# CITY OF ALBUQUERQUE

**Re: 8015 Victoria Dr. NW**  
**Request Permanent C.O. - Denied**  
**Engineer's Stamp dated: 11-20-19 (E10D038)**  
**Pad Certification dated: Not submitted**  
**CO Certification Date: 2/10/2021**

Lots 13, Block 6  
Volcano Cliffs Subdivision, Unit 5  
GRADING PLAN

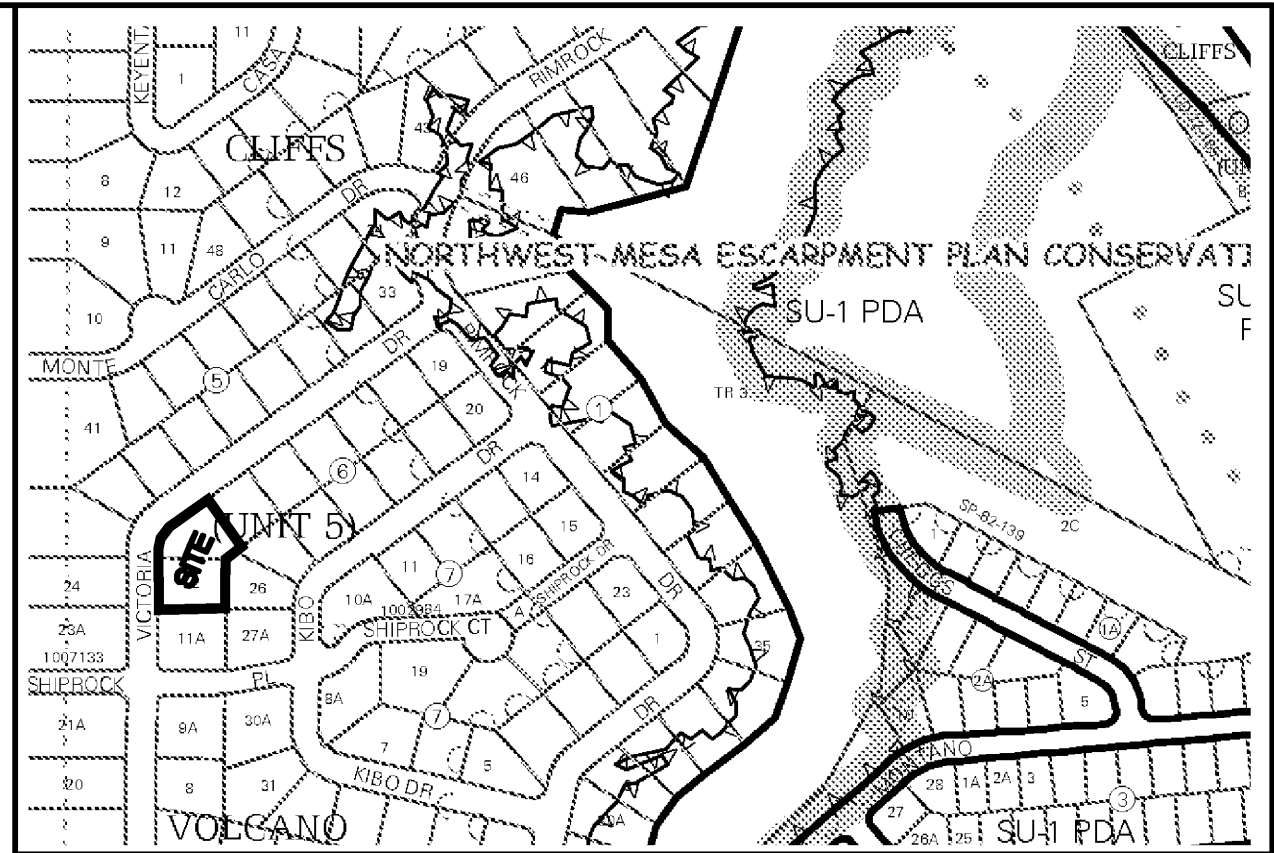
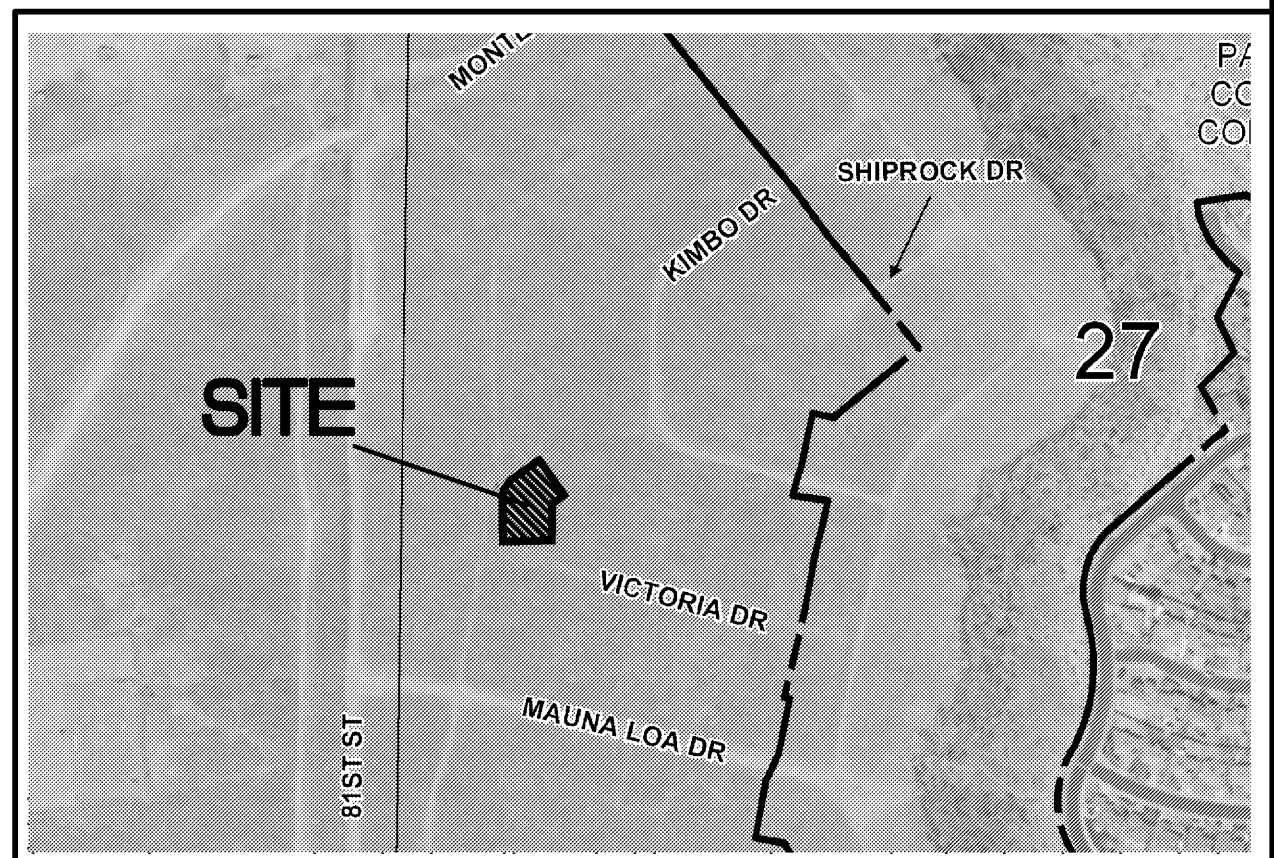
- A pad Certification is required.
- Provide a berm or some type of wall to prevent flows from entering the lot at the NE corner. Picture provided below
